CITY OF ALBUQUERQUE

RE: Eagle Ranch MVD – Retail Drainage Report
Eagle Ranch Rd
Engineer's Stamp Date: 4/24/17
Hydrology File: B13D002C

Based on the information provided in your submittal received on 4/28/17, the Drainage Report is approved for Site Plan for Building Permit. However, prior to Building Permit approval the following must be addressed:

EAGLE RANCH NM MVD - RETAIL
Albuquerque, New Mexico
GRADING & DRAINAGE PLAN
Phase 1 Plan

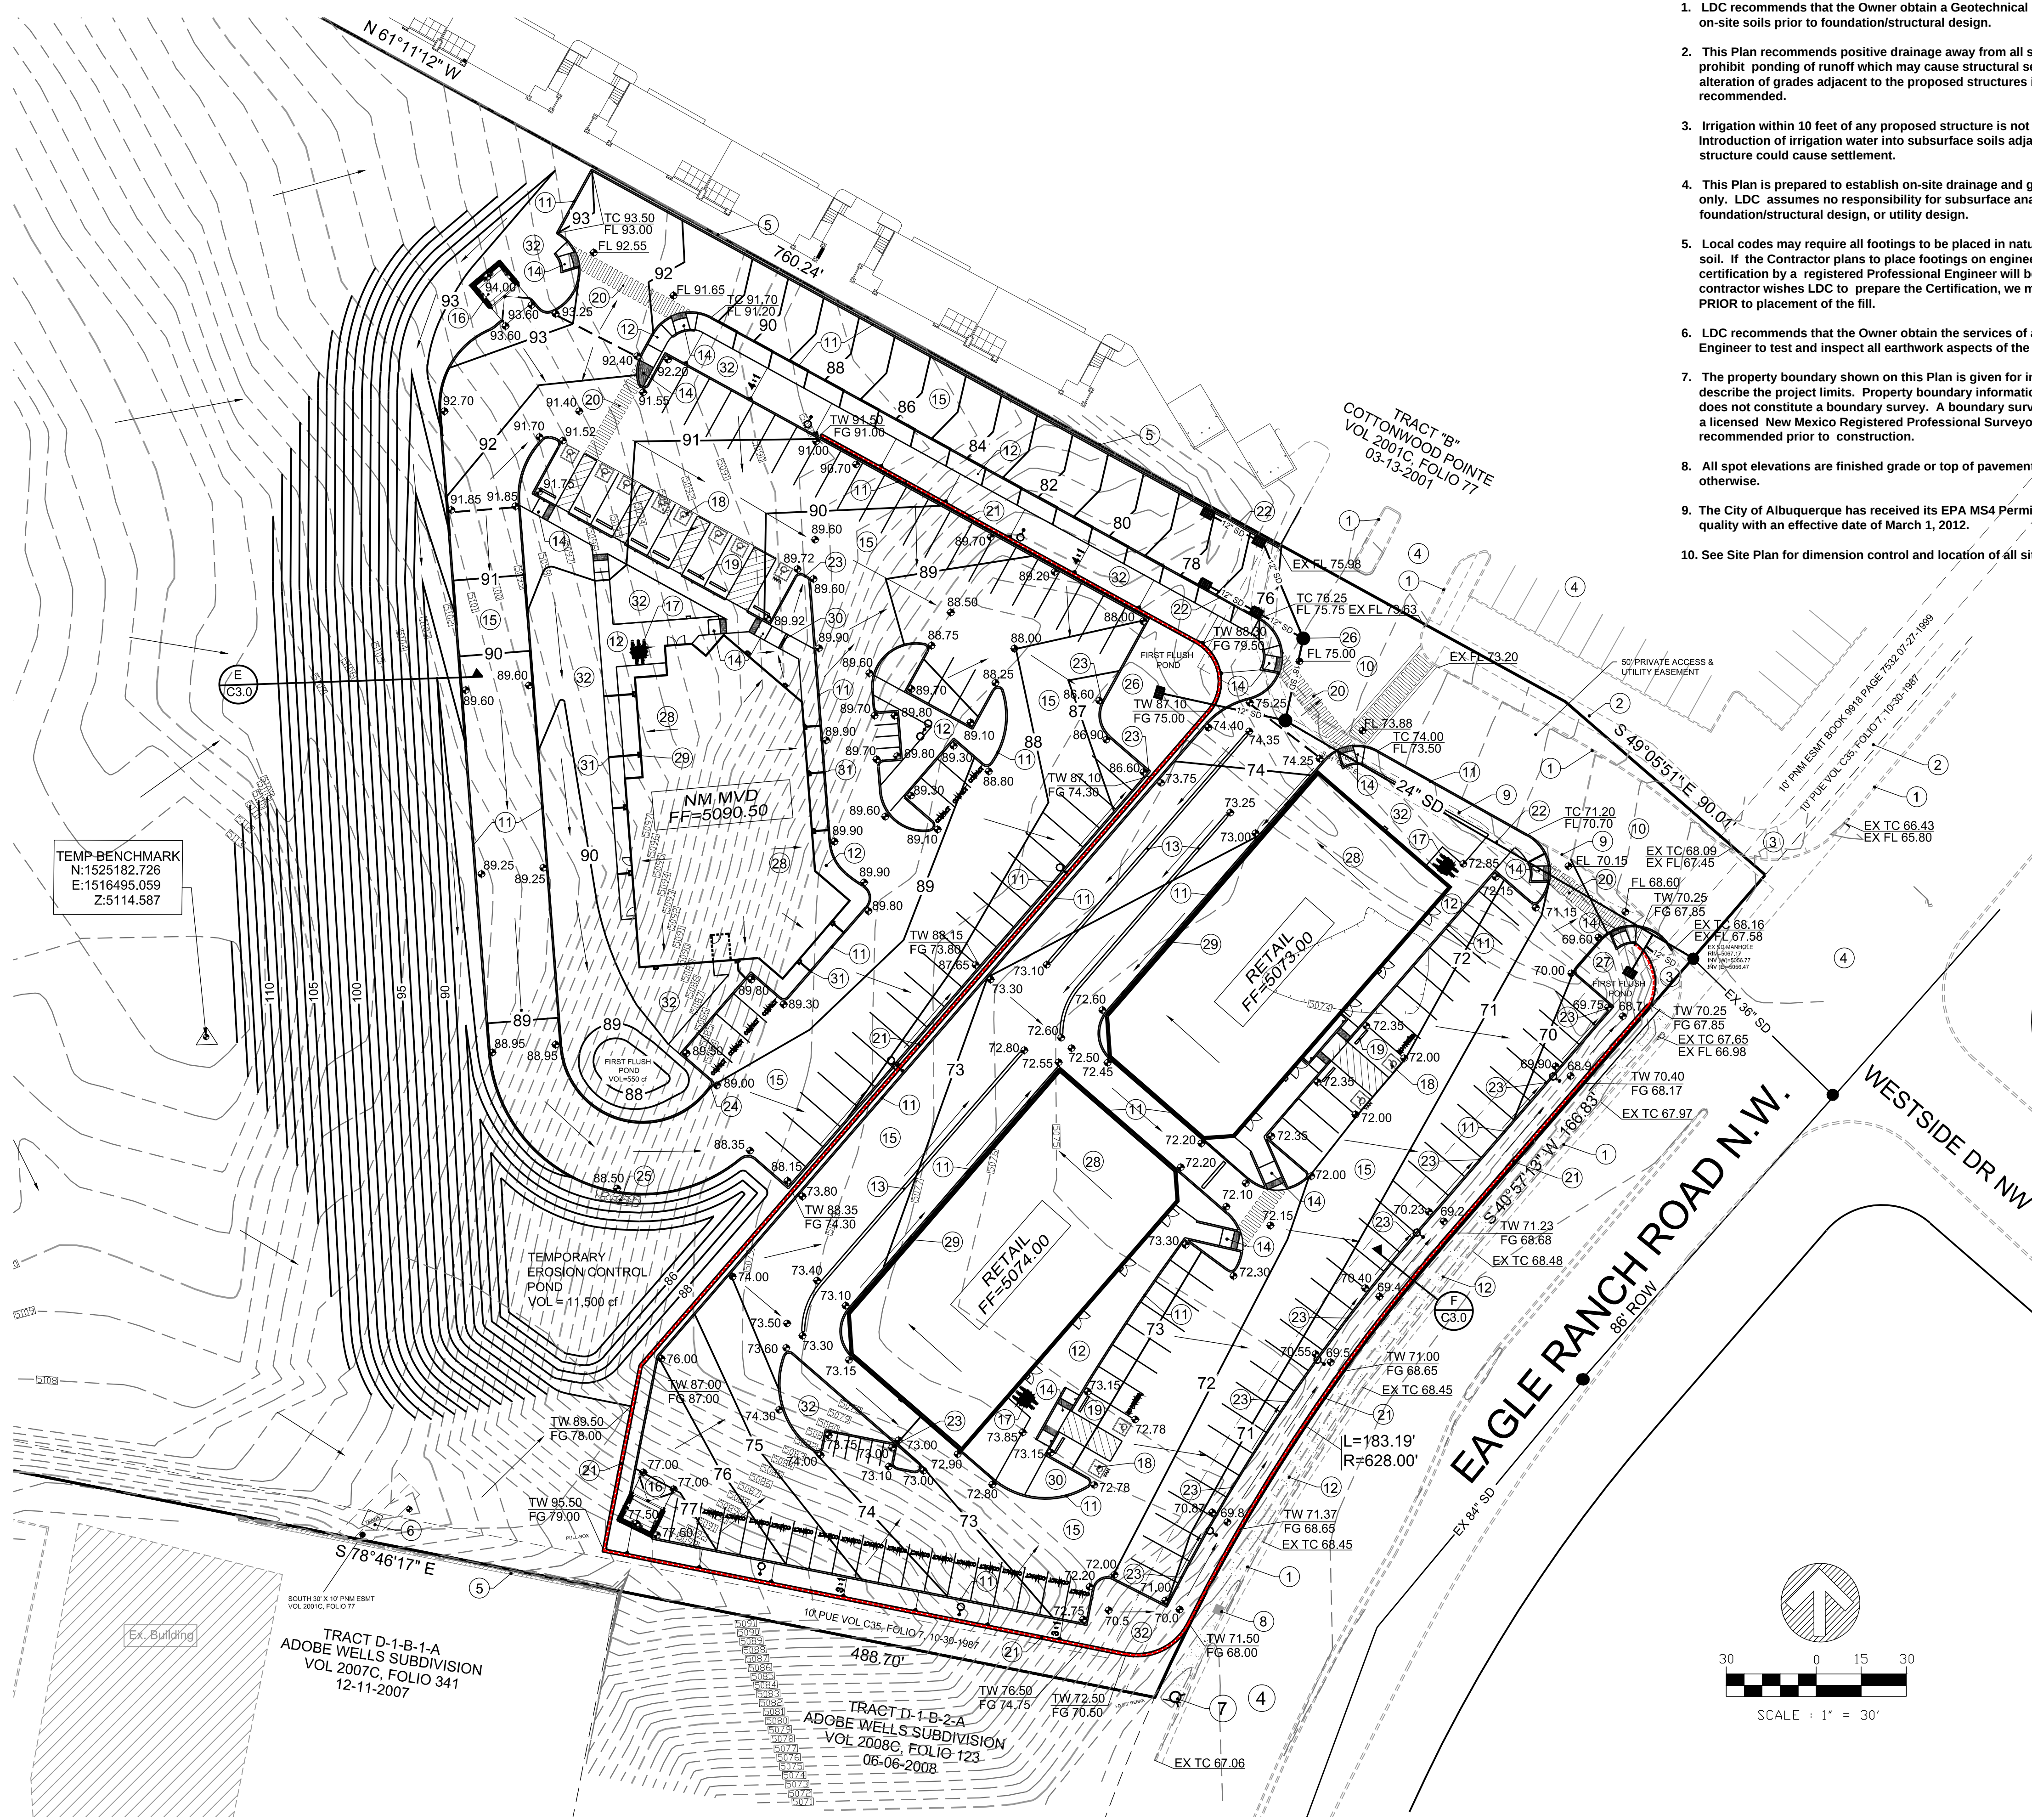
3. Detail how the connection to the storm drain stub off Eagle Ranch will be made:
- The storm drain connection cannot be made as part of the Water Utility Work Order as the City does not review Water Utility work orders.
 - The storm drain, water, and sewer connections can all be made as a City work order or mini-work order and both Water Utility and the City will review.
 - The water and sewer can remain with the Water Utility work order and the storm drain can be done by mini-work order or SO-19 permit. If SO-19 is desired, the sheets will need to include the standard SO-19 language.

Whichever route is taken, the grading and drainage sheets will need to be amended to detail how the storm drain connection is being made.
